Application Ref:	3/2026/0278			 Ribble Valley Borough Council www.ribblevalley.gov.uk
Date Inspected:	19/05/2026	Site Notice:	19/05/2026	
Officer:	MC			
DELEGATED ITEM FILE REPORT:				APPROVAL

Development Description:	Replacement of the existing flat roof and replacement of and removal of rooflights to flat roof. Installation of an air source heat pump to the roof at first floor level with acoustic fencing.
Site Address/Location:	Ribchester St Wilfrids C of E Primary School, Church Street, Ribchester, PR3 3XP

West Elevations (Scale: 1:100)

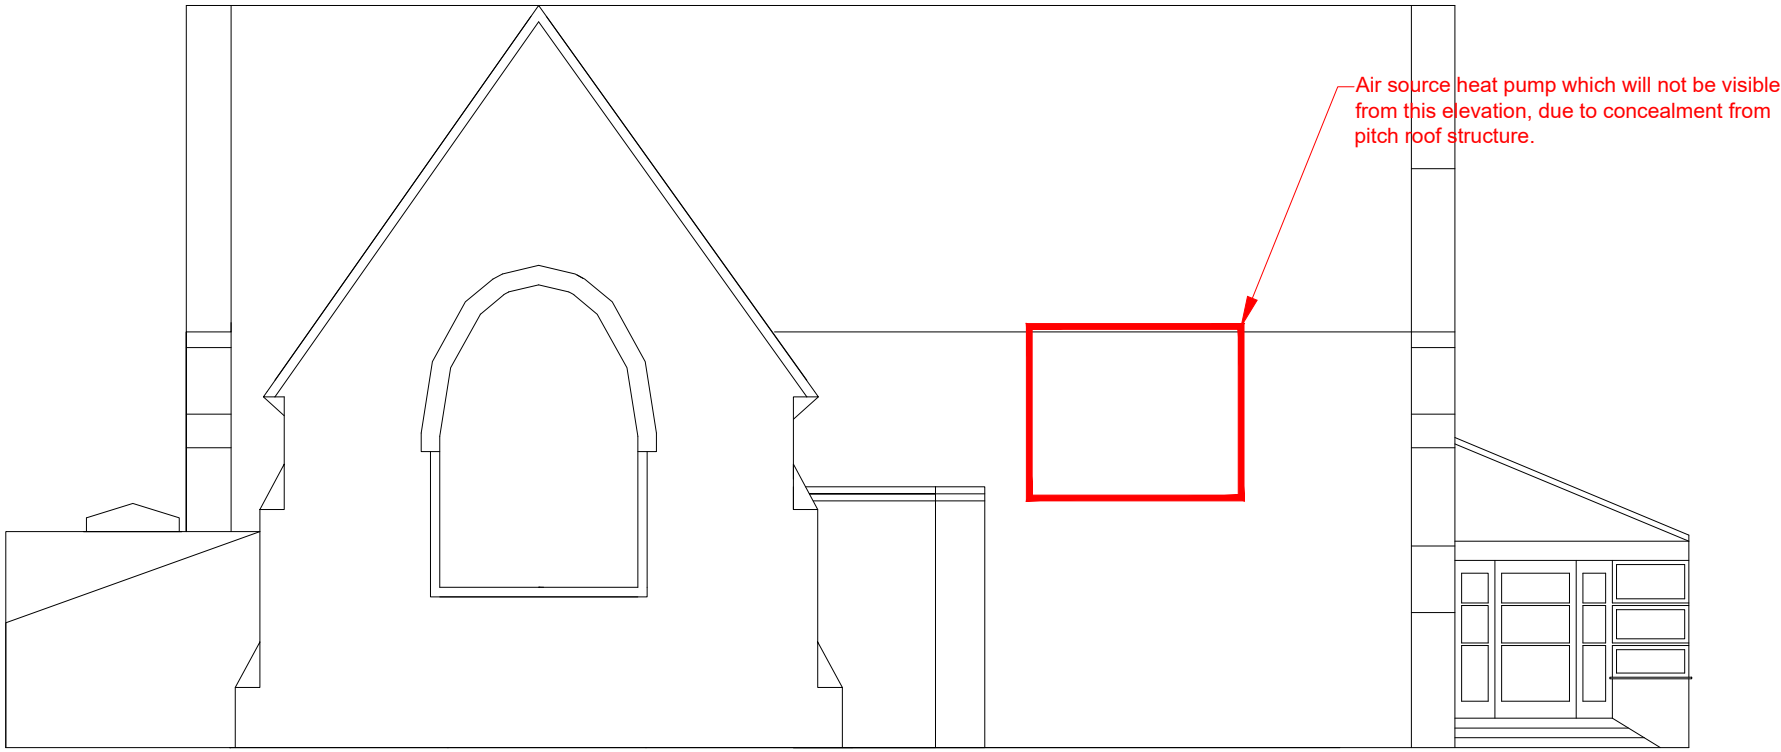
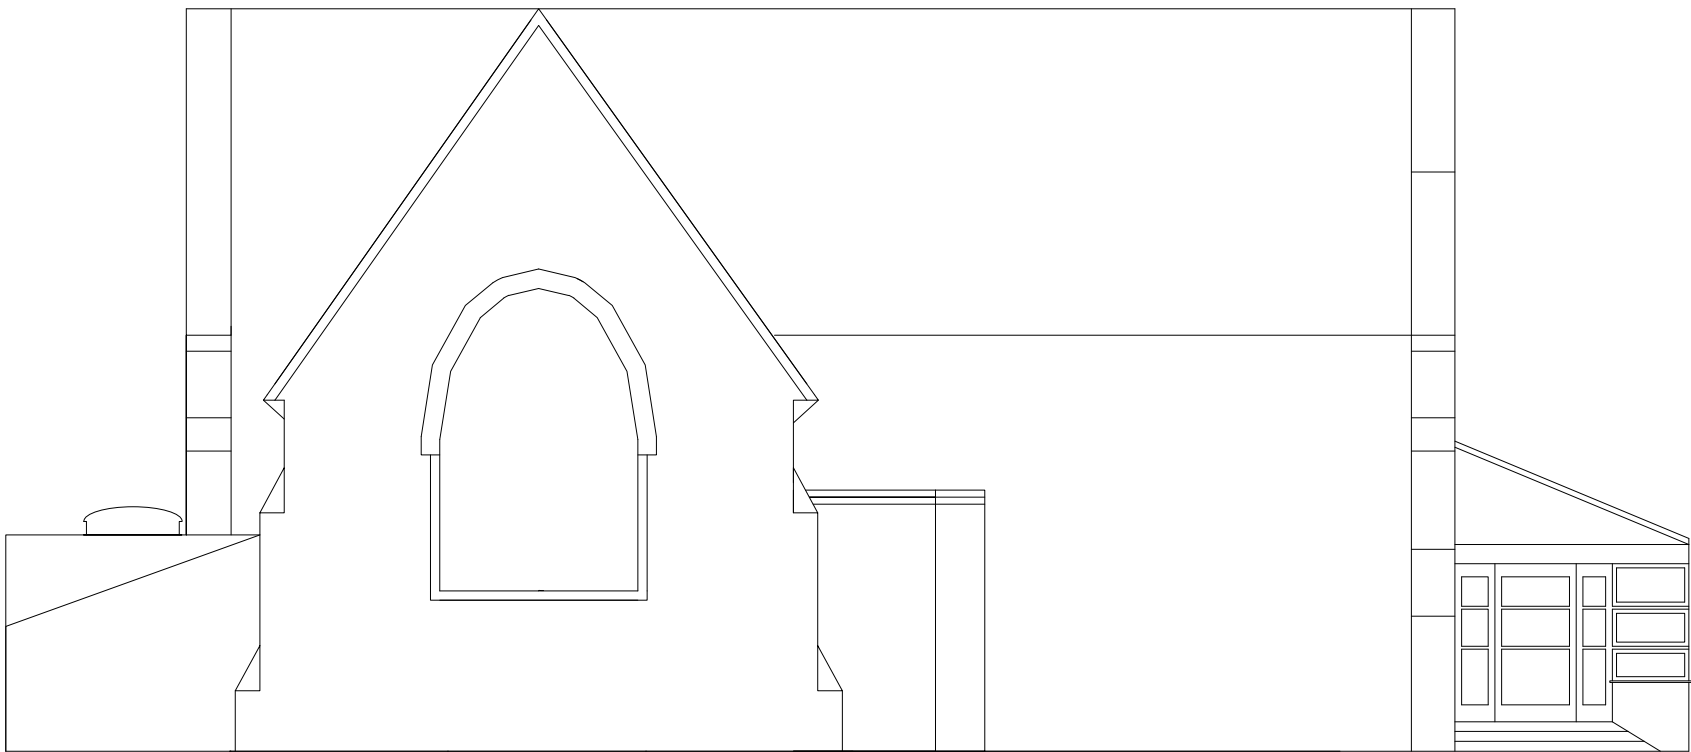
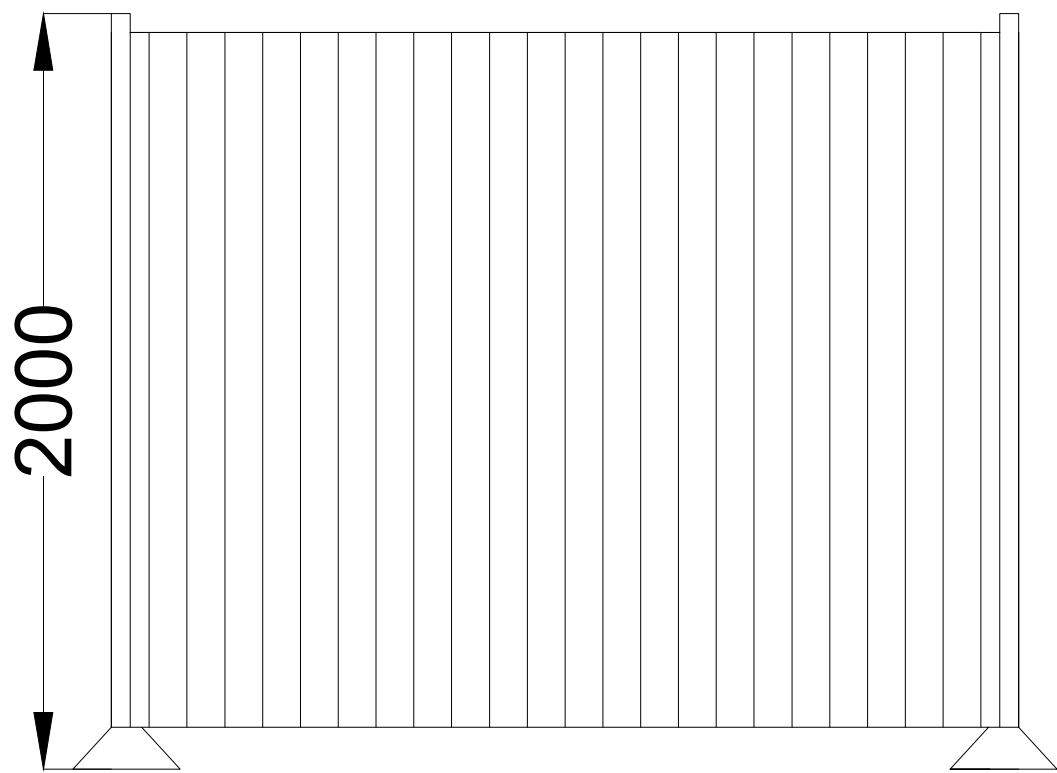
The main impact of the proposed development is the siting, design and materials used for the proposed ASHP and the associated mesh/acoustic fencing. The proposed ASHP would be sited on the roof of the building and therefore could be visible from public vantage points. As such, the location of the ASHP has been set back from the eastern edge of the roof and would now be set back further west to reduce the visibility of the ASHP and the mesh enclosure.

The acoustic fencing is proposed to be constructed in a stone colour, however it is felt that a darker grey colour would be more in keeping with the existing roof. As such, an alternative colour could be secured by way of planning condition.

Subject to conditions, the amended location of the ASHP is considered to be acceptable as it would not be as highly visible from within the Conservation Area and measures have been taken to reduce the visual prominence from views within the public realm. As such, it is considered that the character and appearance of the Ribchester Conservation Area would be preserved and the proposal accords with Key Statement EN5 and Policies DMG1, DME4 and DME5 of the Ribble Valley Core Strategy and Section 16 of the NPPF.
